CITY OF ALBUQUERQUE

April 17, 2025

**RE: ABQ Biopark SHARC
2601 Central Ave NW
Grading and Drainage Plans
Engineer's Stamp Date: 3/25/25
Hydrology File: J12D004
Case # HYDR-2025-00125**

Based upon the information provided in your submittal received 04/14/2025, the Grading & Drainage Plans **are not** approved for Building Permit and Grading Permit. The following comments need to be addressed for approval of the above referenced project:

A1 FLOOD ZONE MAP  
FLOOD ZONE MAP: 35001C0331H

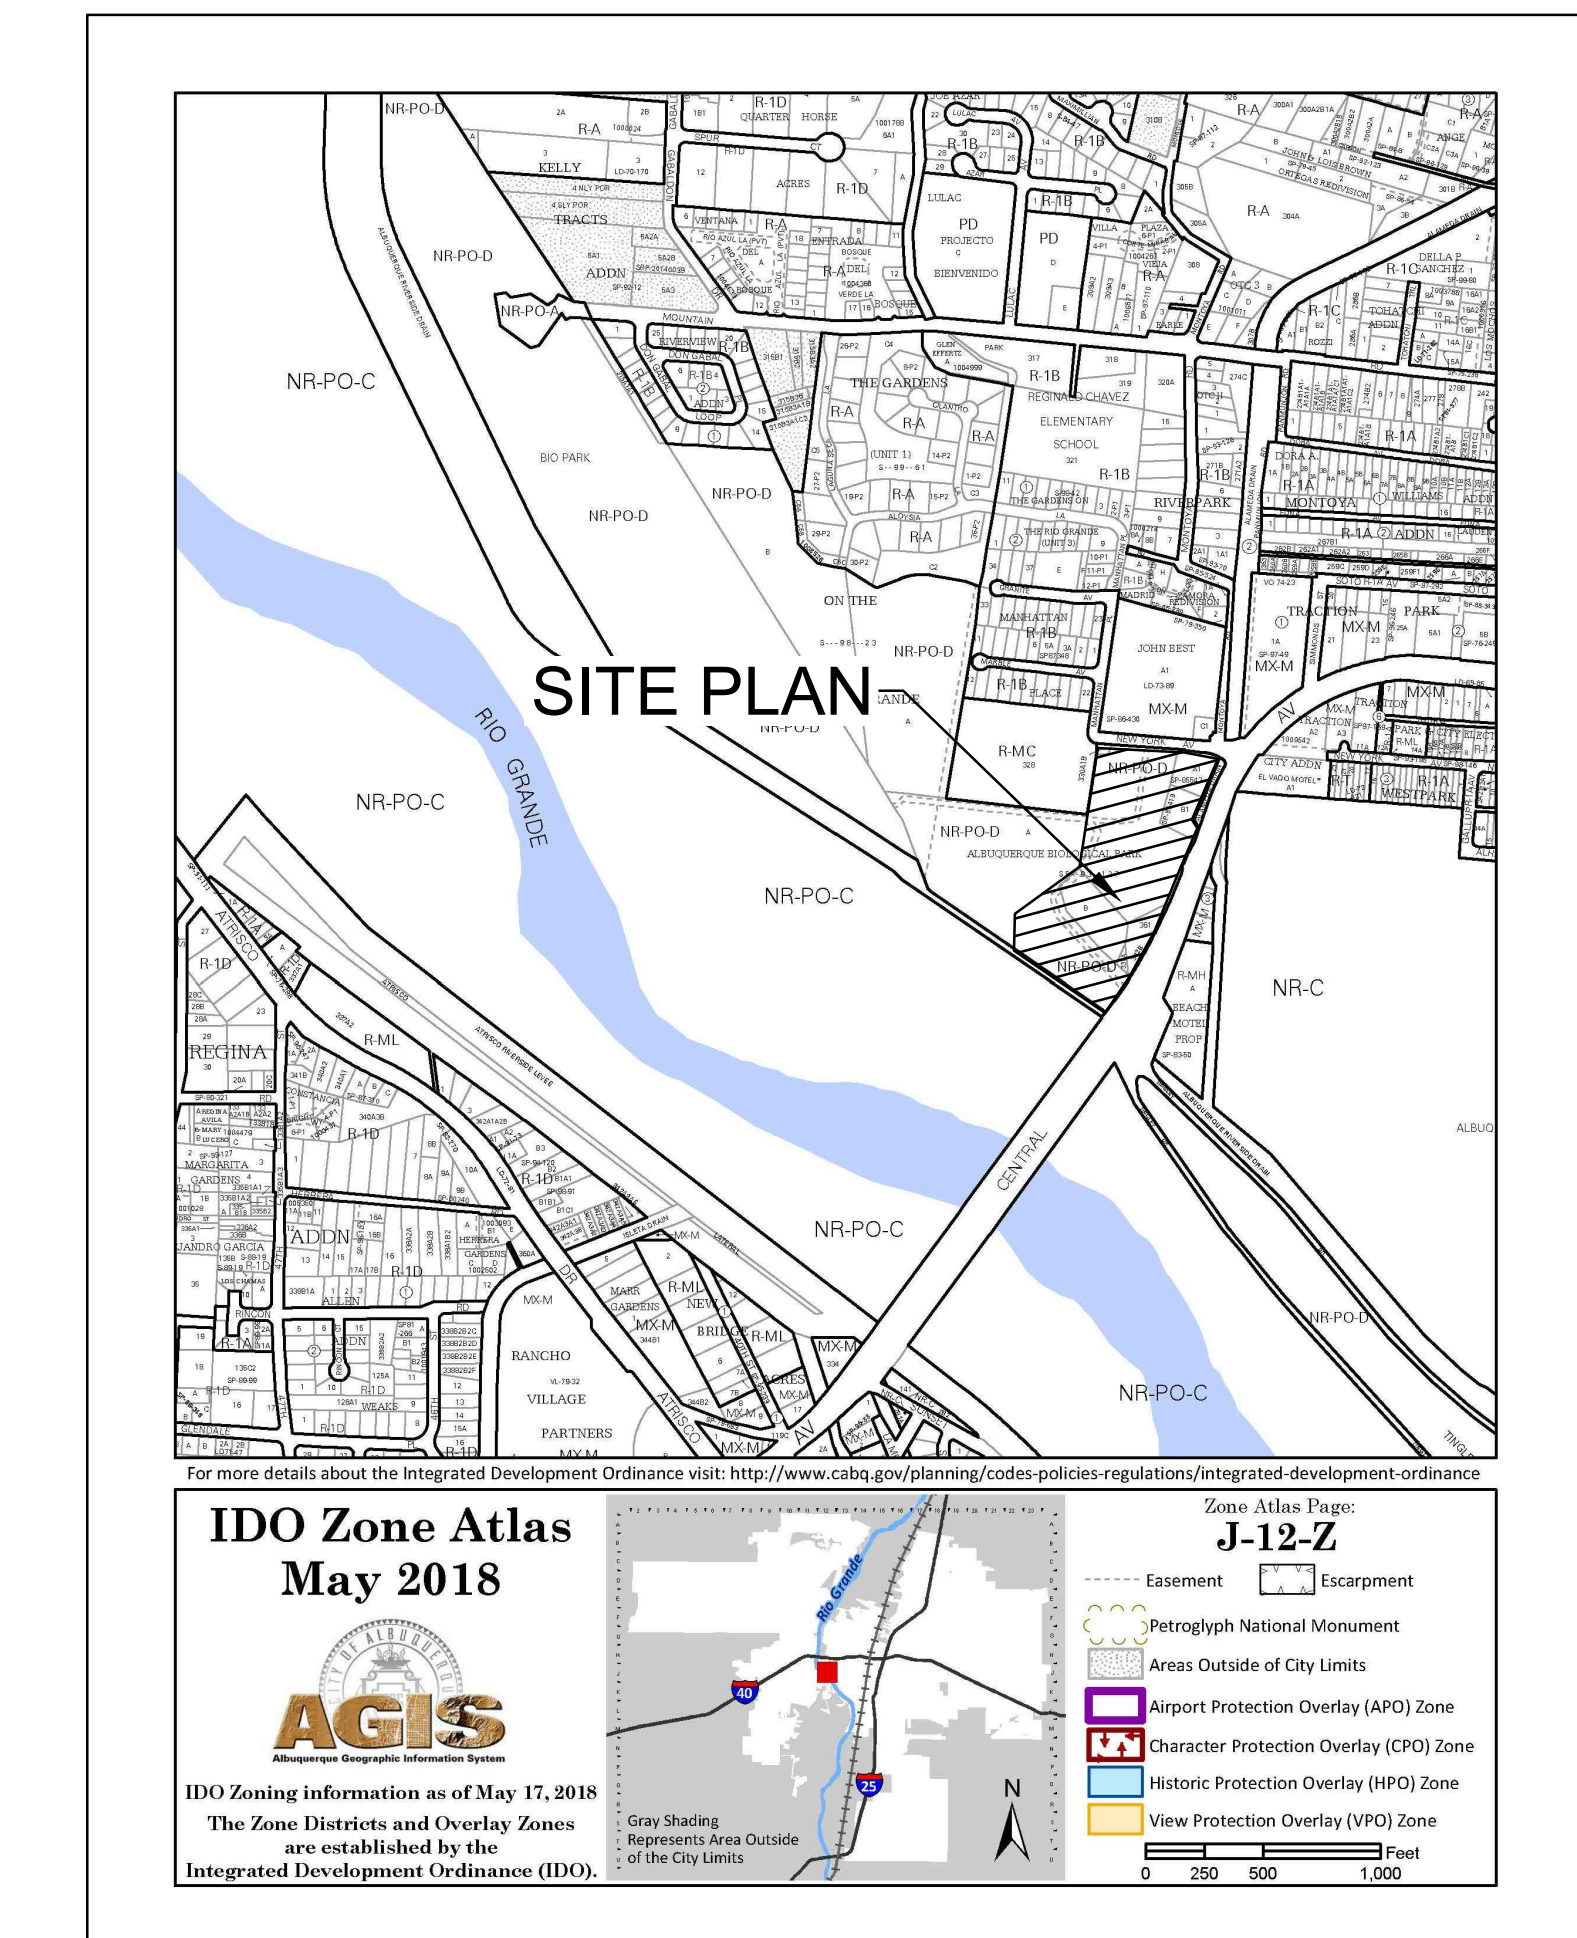
1. Include project benchmark and datum information (location, description and elevation) for the survey contour information provided.
2. Please provide the FIRM Map and floodplain note with effective date.

SHEET NO: C-100

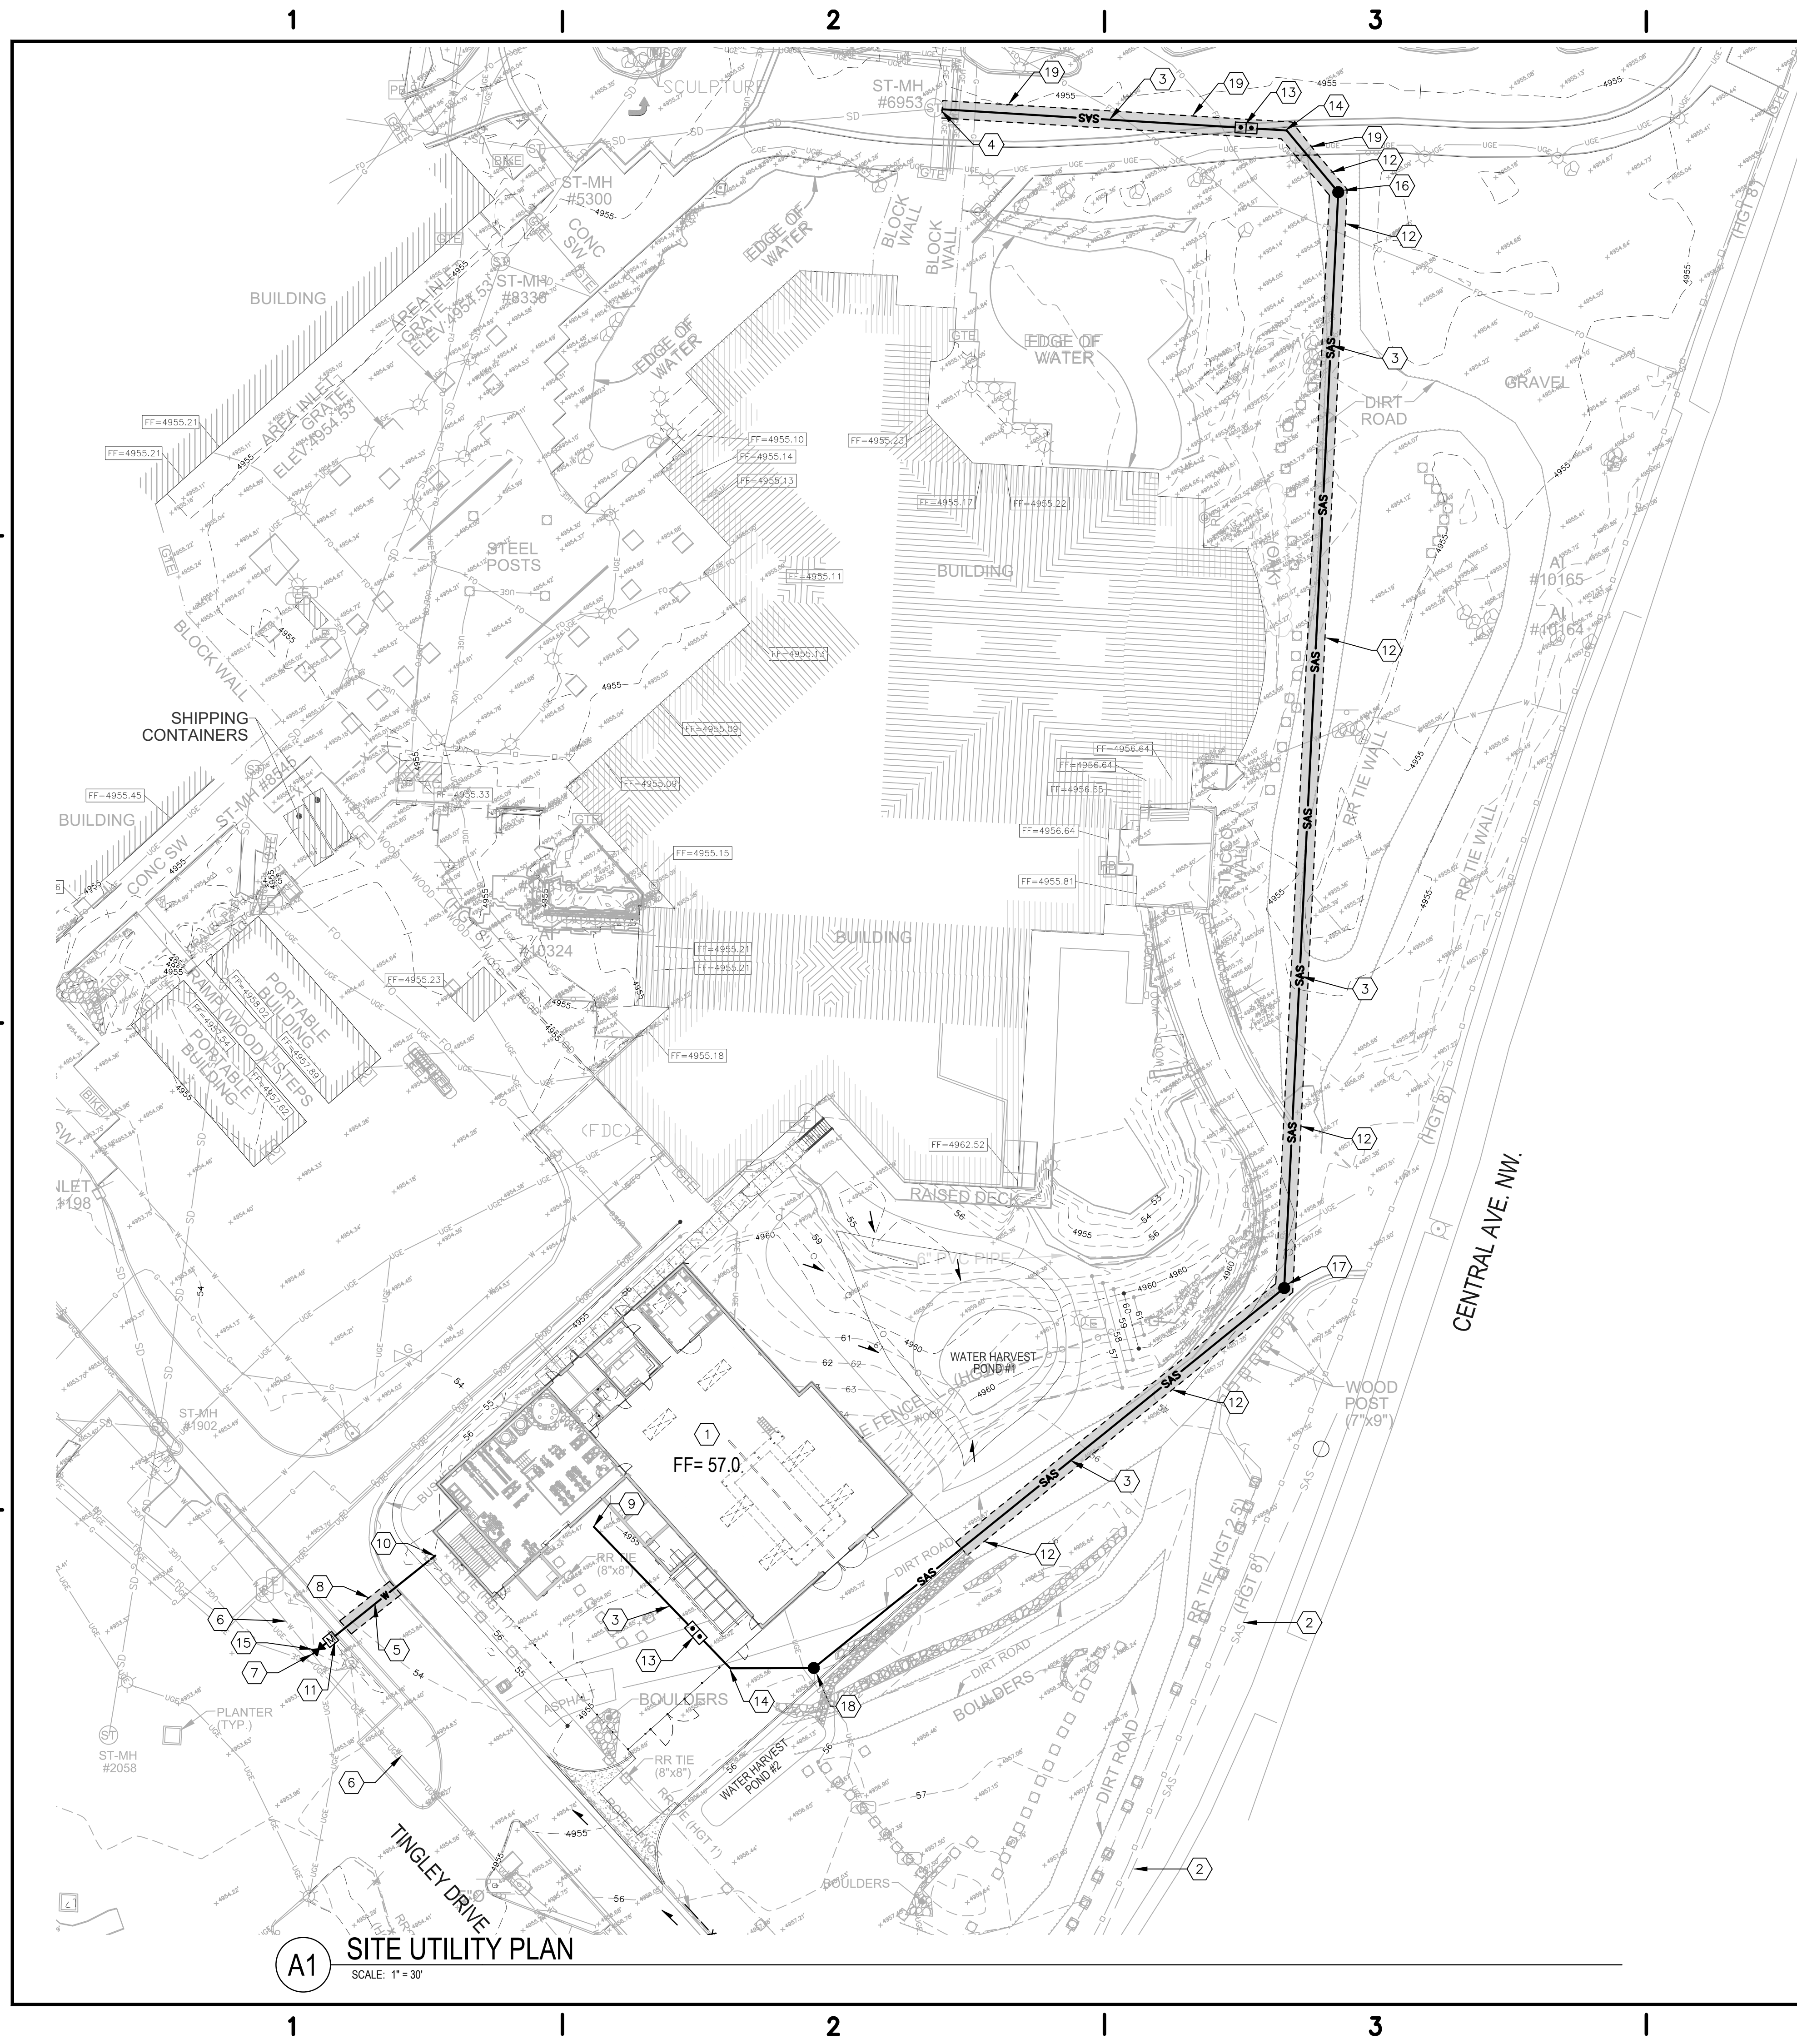
3. Please provide the legal description of the property.
4. Please provide a Vicinity Map. This can be downloaded in pdf format from the City of Albuquerque's website.

5. Please number the ponds and include a label on each with the SWQV and elevation, the 100-year volume and elevation, the peak 100 year inflow and outflow, the spillway crest elevation, the spillway flow depth, and the dam top elevation.

6. Please provide the SWQV calculations for each basin draining to each pond. The stormwater quality ponds need to be sized for the areas draining to them.

7. This site qualifies as redevelopment and is only required to retain runoff from the 80th percentile storm (Vol. = 0.26"*Imp.Area).
